Your Ref: OWPC20547
Our Ref: FG/170/18/HH 18-09-2018
Please ask for:
Zac Denton

Single storey extension to east elevation.
Pied a Terre Ferring Street

Thank you for your internet representation made on 12th November 2018 which has been recorded as '**an objection**' with the comments as follow s:

Proposed Site Layout

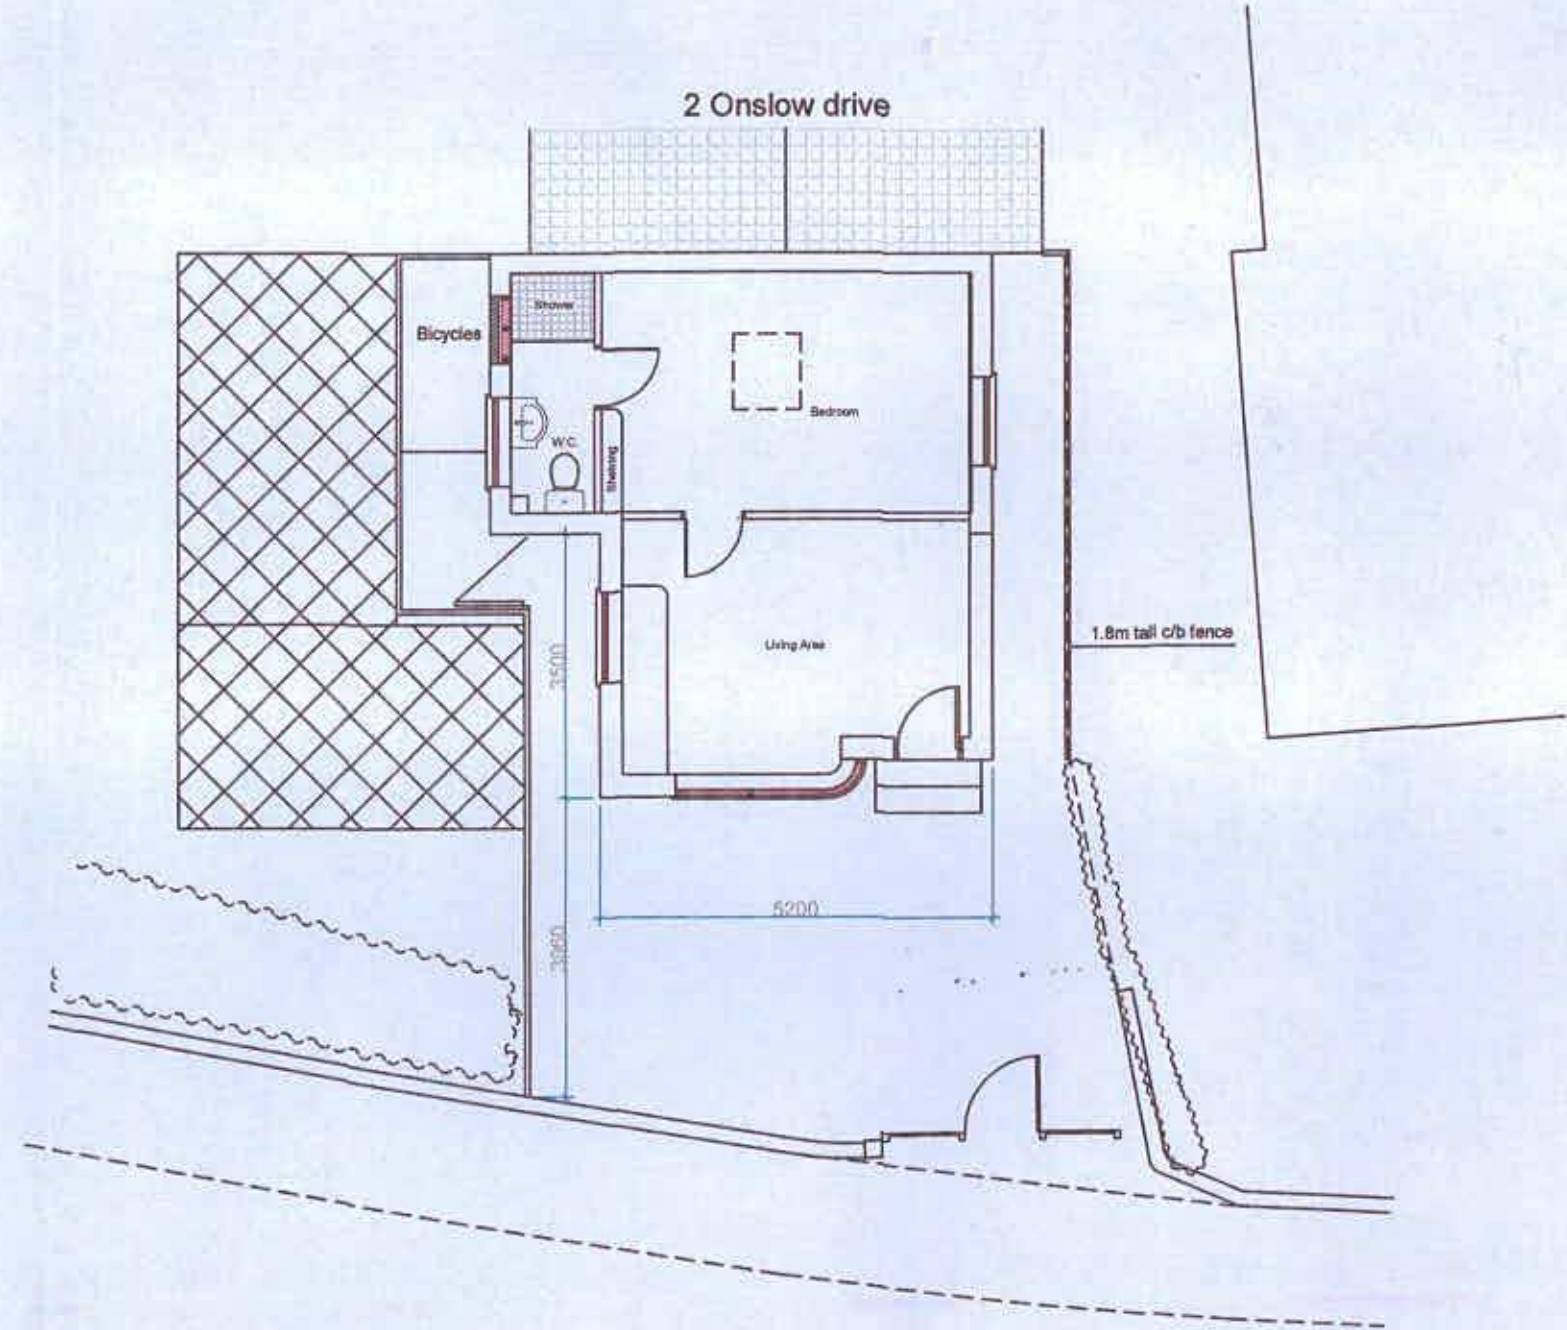
There are no car parking facilities - presumably owners would have no private vehicle and a ban would be included as a restriction

Proposed Floor Plan

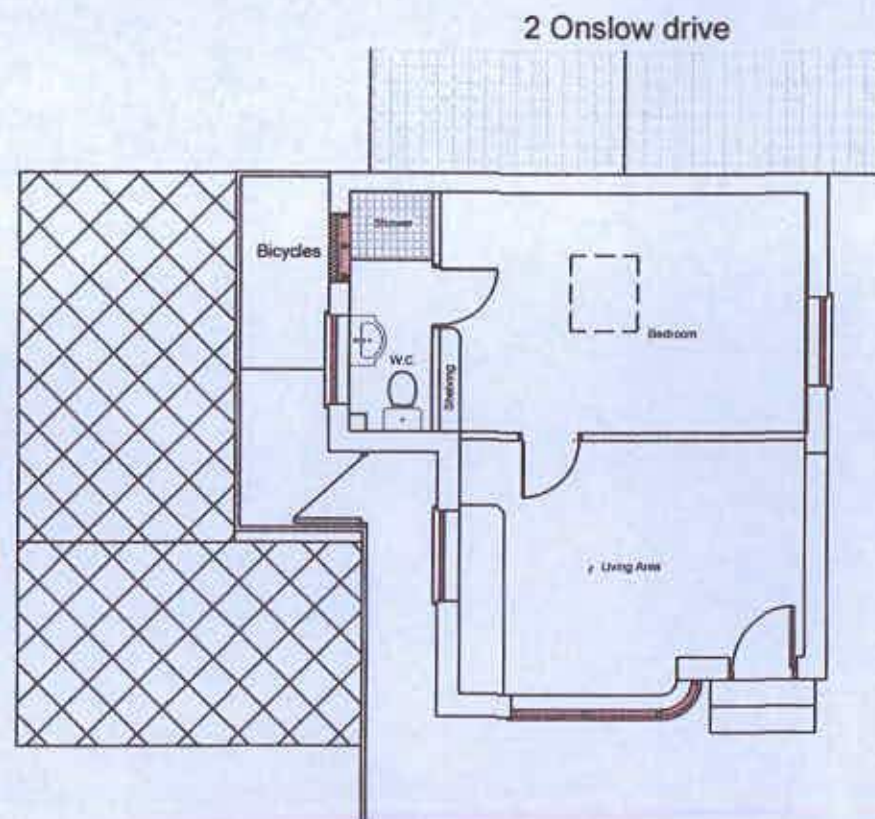
There are no kitchen facilities included

The bathroom is limited to a toilet and wash stand - no regular bathroom
